# ENG-SF18020-R1-FDR.pdf Markup Summary

DSD Proj  
**SF-1820**

# Grading Eros Plan V\_1.pdf Markup Summary

OFFSITE DRAINAGE DITCH GRADING AND EROSION CONTROL PLAN
 SCALE: 1"=50'

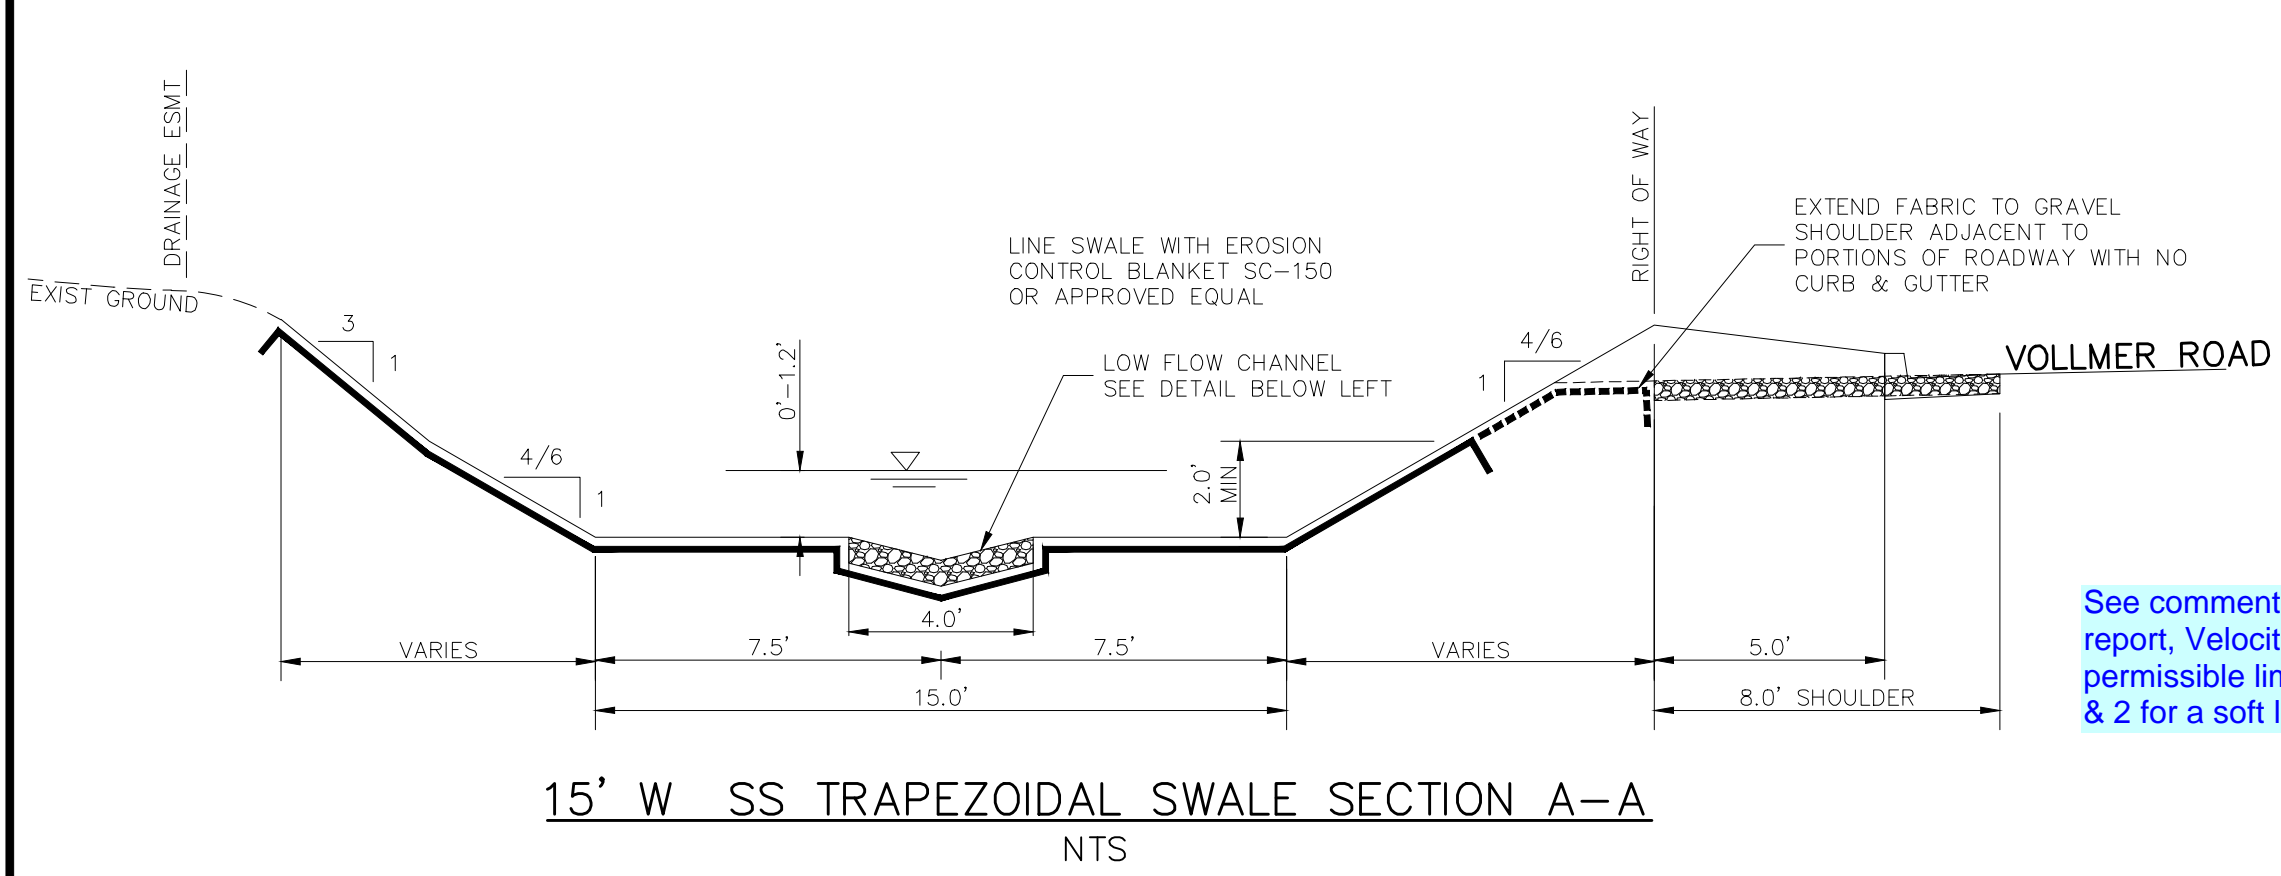
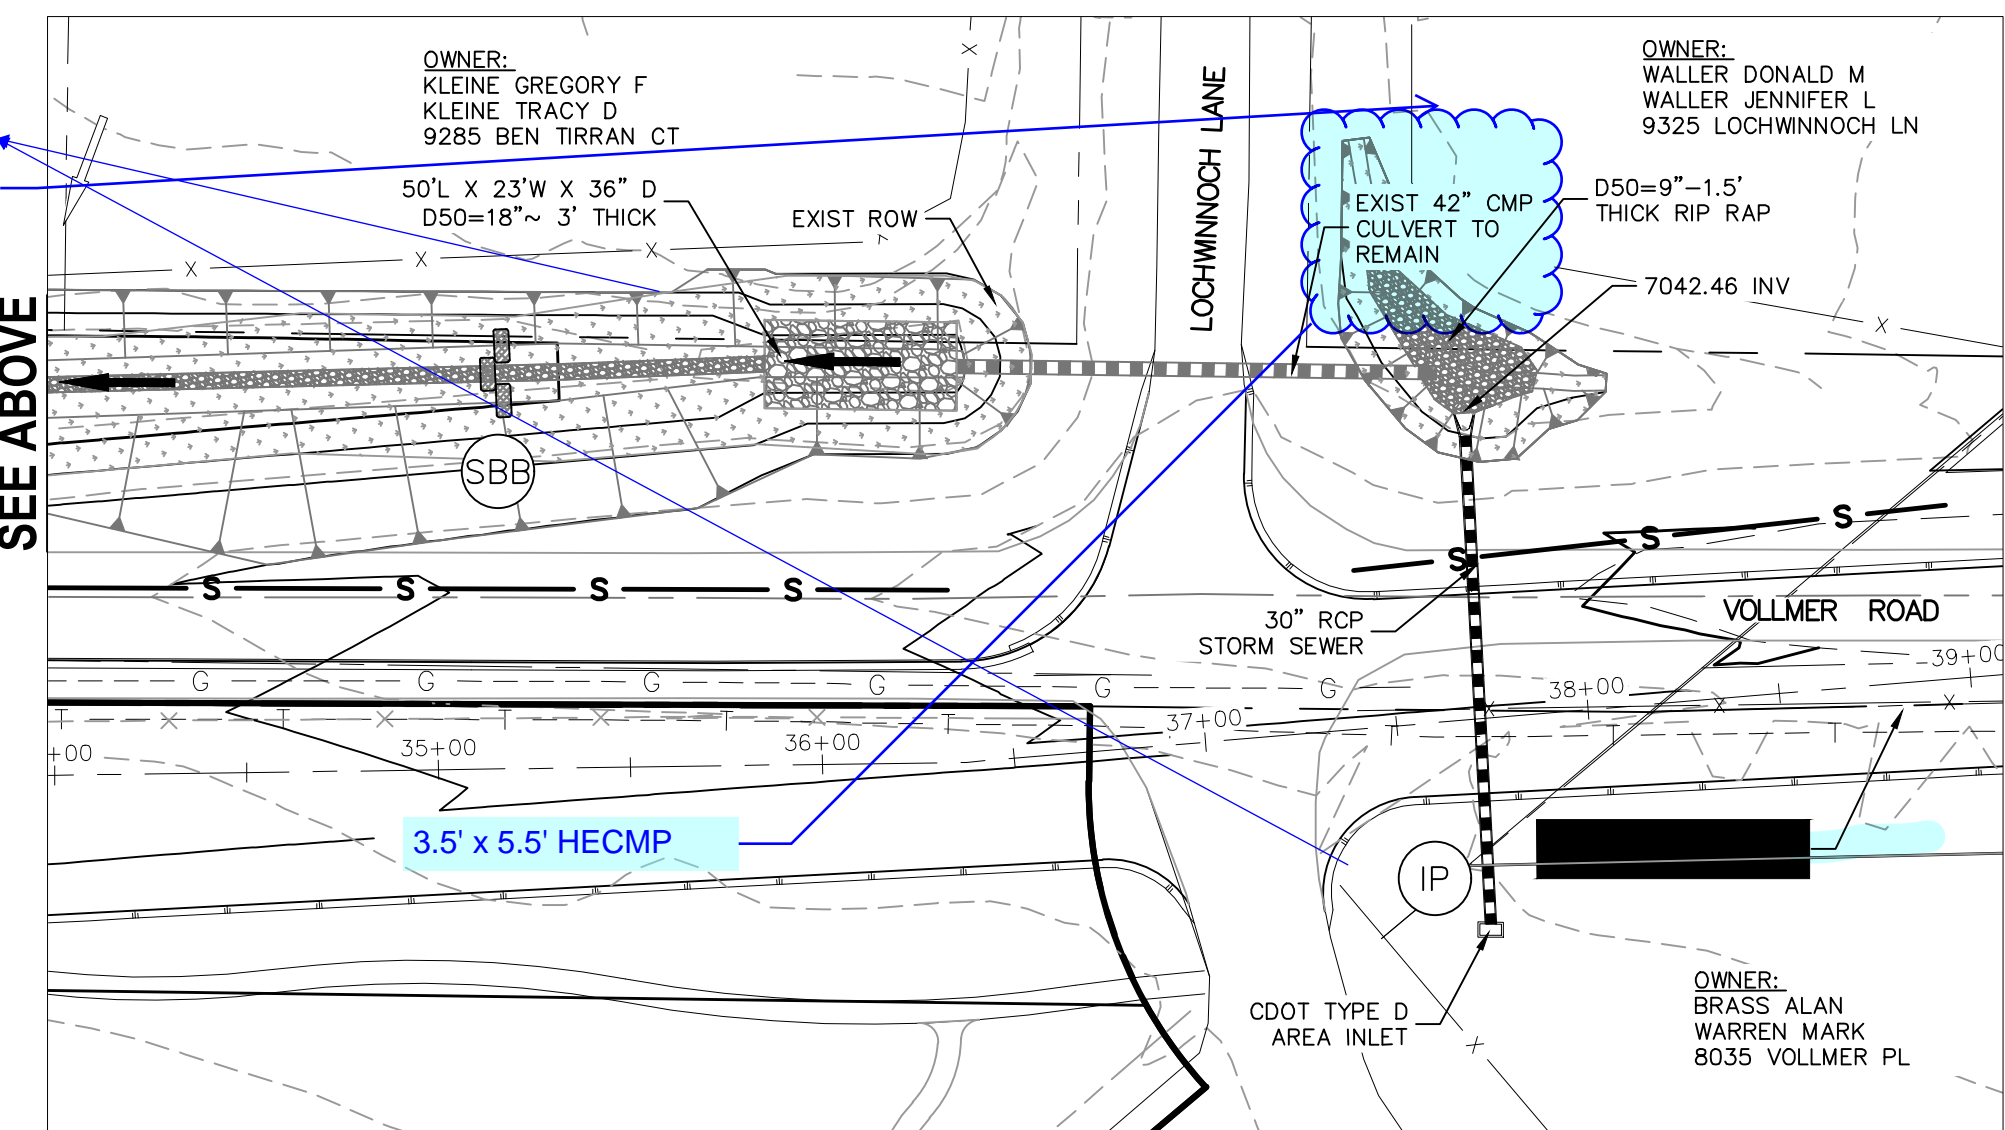
See comments on the Drainage report. The size of the flows in this graded channel will require armoring/channel design to prevent erosion.
